PLANNING CONSULTATION RESPONSE

Application No	2026/0363
Proposal	Demolition of existing garages and erection of detached dwelling with detached garage and associated works.
Address	Land adjacent to 113 Hoyland Road, Hoyland Common, Barnsley.
Date of Consultation Reply	23/06/2026
Consultee	Edward Jowett (Tree Officer)

Project	Detached Dwelling
Client	Mr Shane O'Keefe
Title	Ground Floor Layout
Address	Adj. 113 Hoyland Road, Hoyland Common, Barnsley. S74 0AP
Drawn By	GGG
Scale	1:50 @ A3 Date Apr 26
Drawing No	531-04 Rev

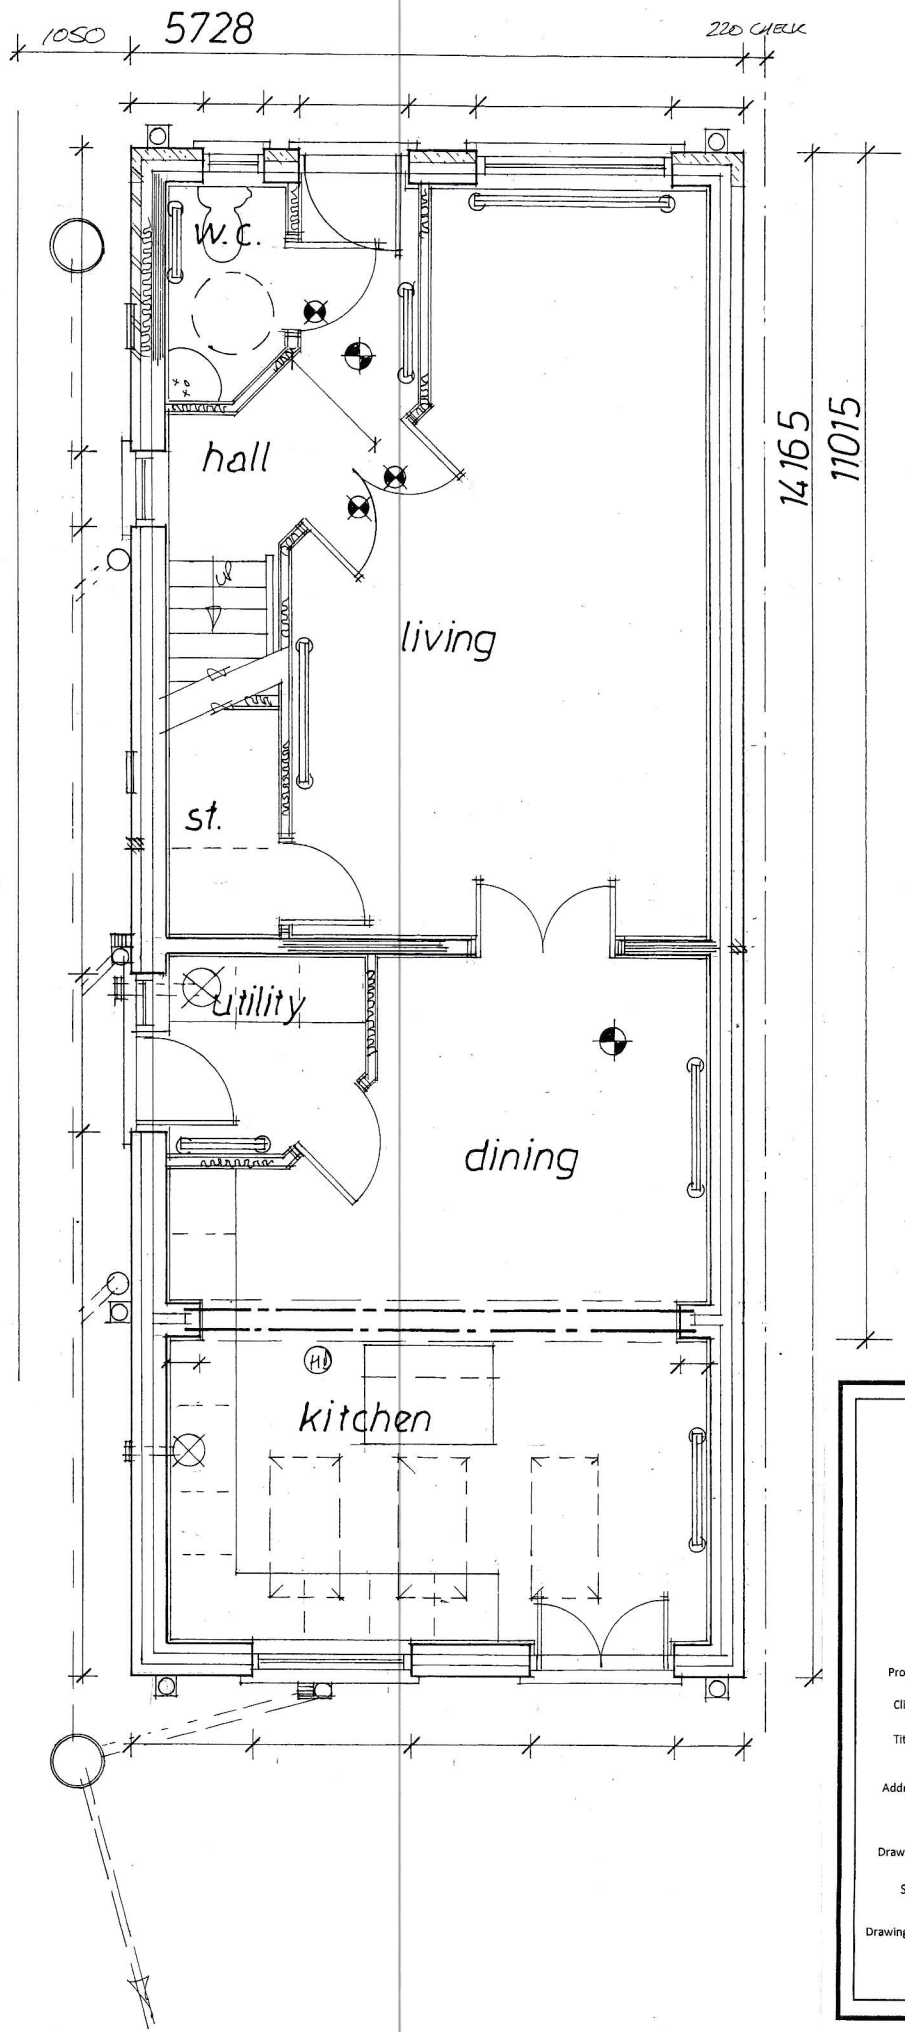
I do have some concerns over the proximity of T1 to the proposal; the level of overhang is only minor and should not normally pose a significant constraint however the size and shape of the plot mean this could potentially be a significant issue. The proposed dwelling is being built tight up against the boundary of the site immediately adjacent to the existing footpath. The plans provided show that this means the proposed dwelling will impact directly on the Council owned tree both in terms of direct contact with the canopy of the tree and the minor encroachment into the rooting area. No arboricultural impact assessment or impacts plan have been provided to deal with this only the baseline tree survey.

Project	Detached Dwelling	
Client	Mr Shane O'Keefe	
Title	Site Layout	
Address	Adj. 113 Hoyland Road, Hoyland Common, Barnsley, S74 0AP	
Drawn By	GGG	
Scale	1:200 @ A3	Date Apr 26
Drawing No	531-01	Rev

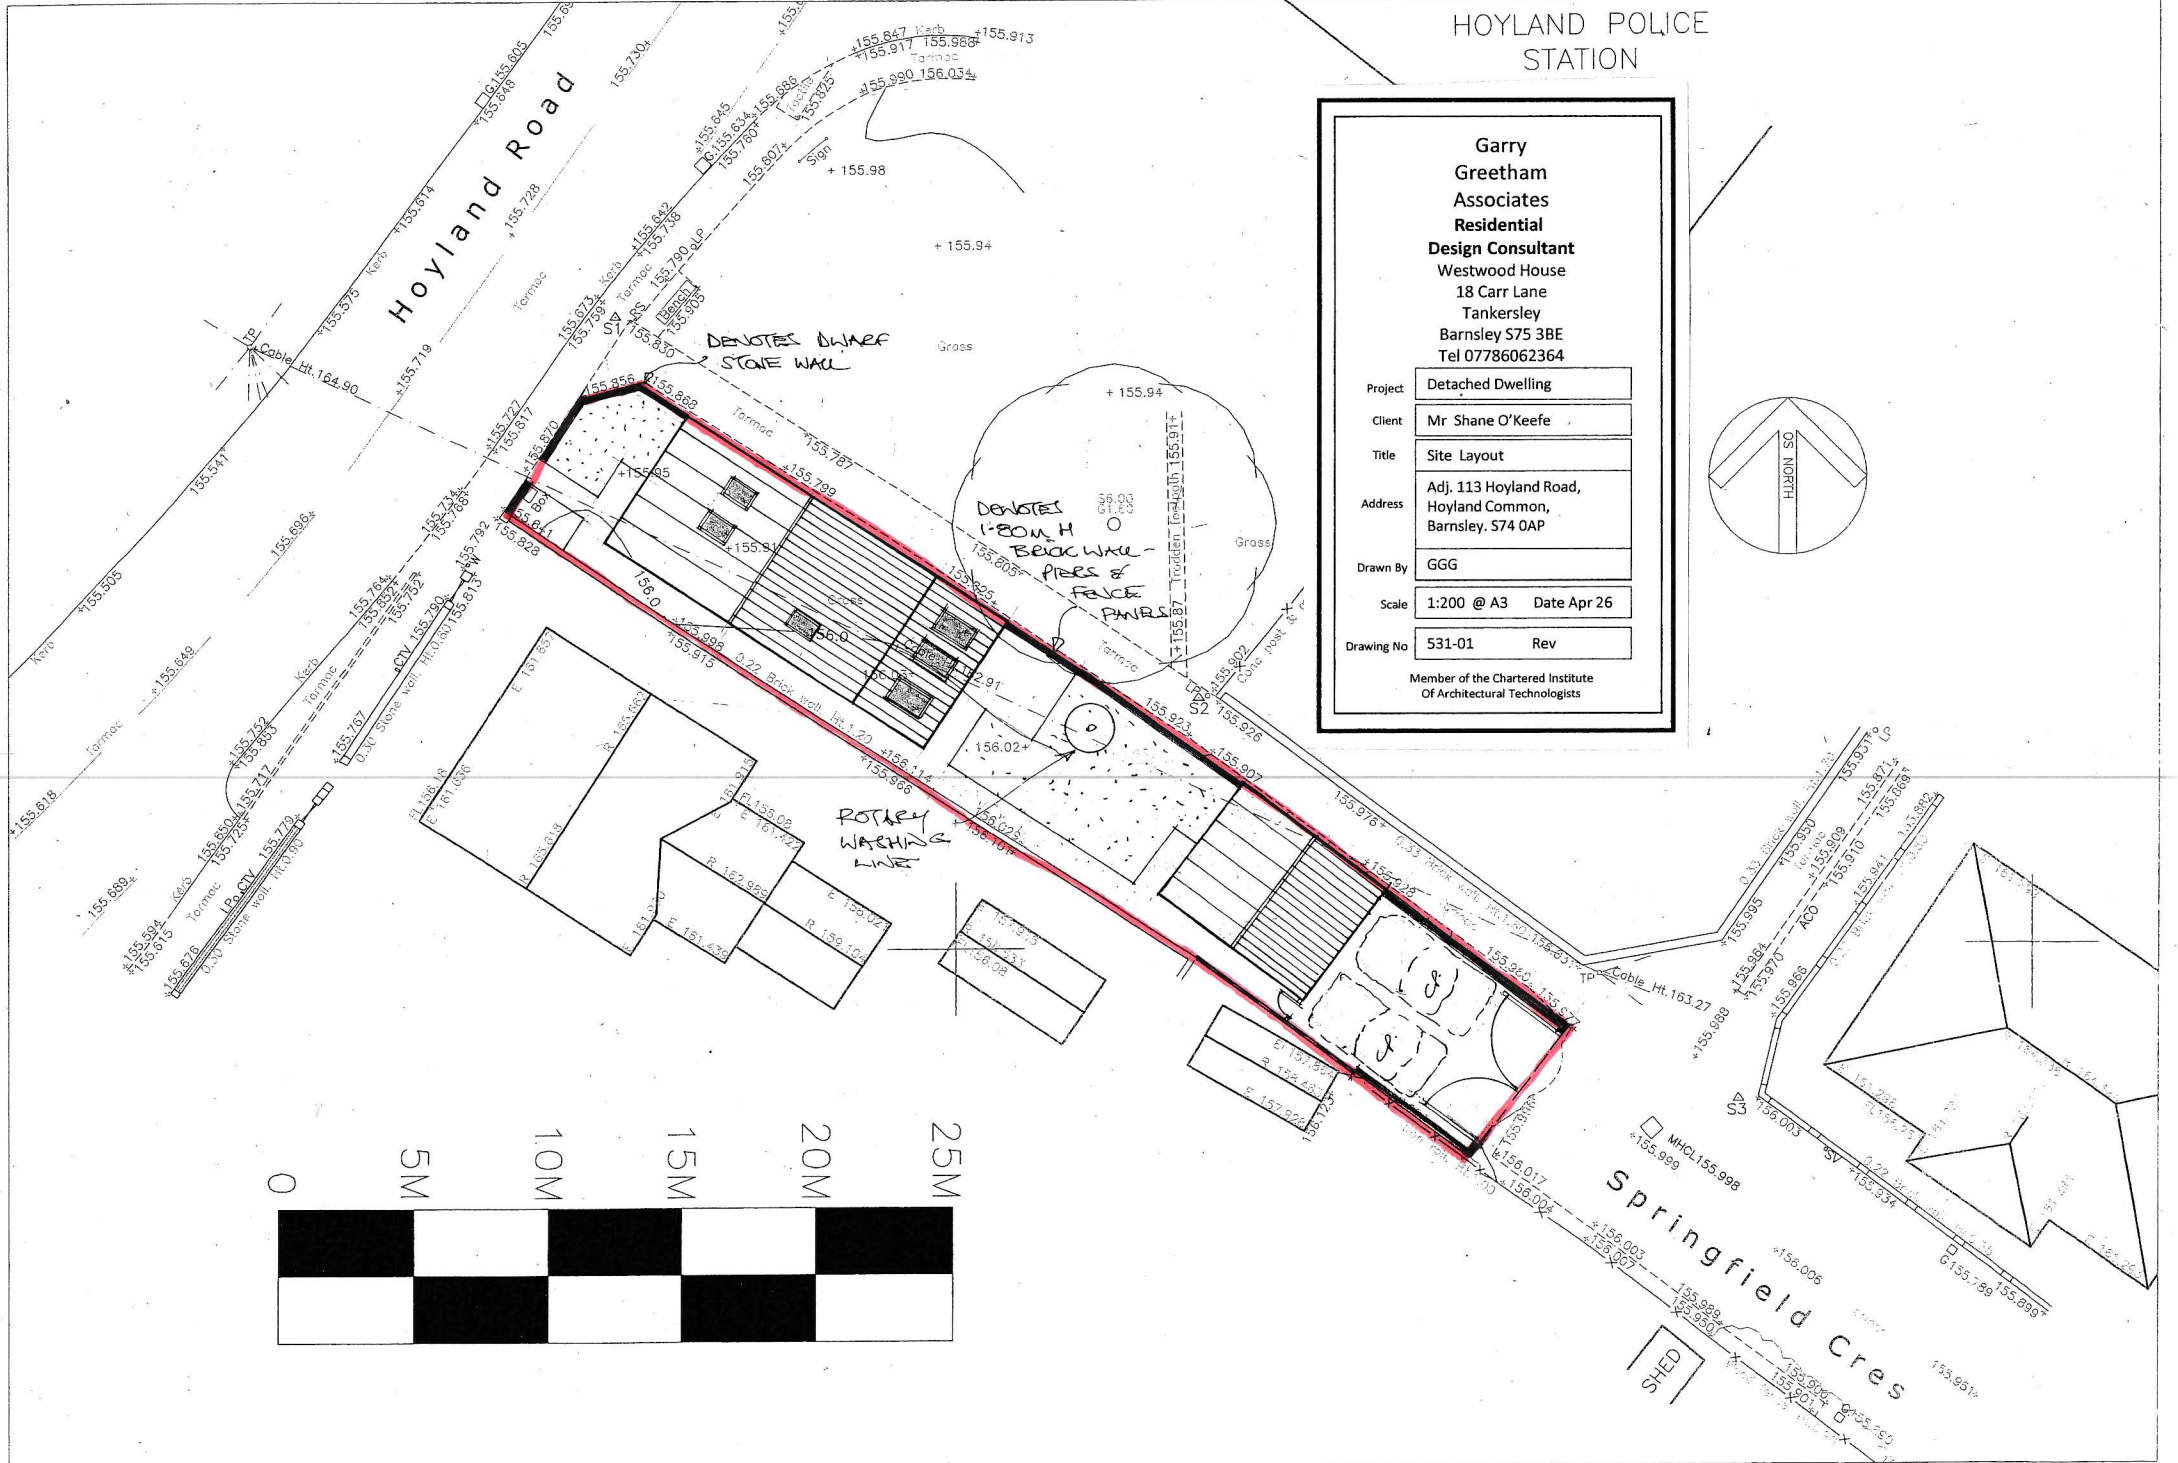
There are three early mature Norway Maple trees located off site one of which (T1) overhangs into the site slightly and whose rooting area also encroaches. The location of the trees and their prominence to the street scene and position within a small area of Council owned public open space mean they have high amenity value.

The encroachment into the RPA is only minor and appears to be well within the limits of what could be tolerated by the tree without detriment; providing suitable foundations are used there should be no future issues for either the tree or dwelling. My main concern however is direct contact between the canopy and the proposed dwelling as ultimately any pruning works would only go back as far as the boundary/build line without permission to work on council owned land or the Councils tree team agreeing to do the works. This in itself may not be insurmountable particularly as it is the single story element of the proposed dwelling which would directly impact on the very bottom of the trees canopy, however I would have concerns over ongoing maintenance. The tree is still early mature and as such still has the potential for future growth and as such I would have concerns over ongoing maintenance and potential future conflicts and pressures on the Council as owners of the tree; particularly as proximity issues could not be resolved in the usual way by a property owner exercising their common law right to cut back to the boundary line as the dwelling sits right up to it. This would make it impossible to achieve clearance between the tree and the dwelling without the repeated and continuous involvement of the Council as the tree owners. I therefore have significant concerns regarding this becoming a management burden for the Councils tree teams and potentially becoming an area of conflict, leading to future pressure on the Council and the tree for significant works or even removal.

In order to resolve this I would ask that an arboricultural impact assessment be produced to deal with the direct impacts and how these would need to be managed and also liaise with the Councils tree team and the department who owns them to ascertain their thoughts on future management burden and potential conflicts.
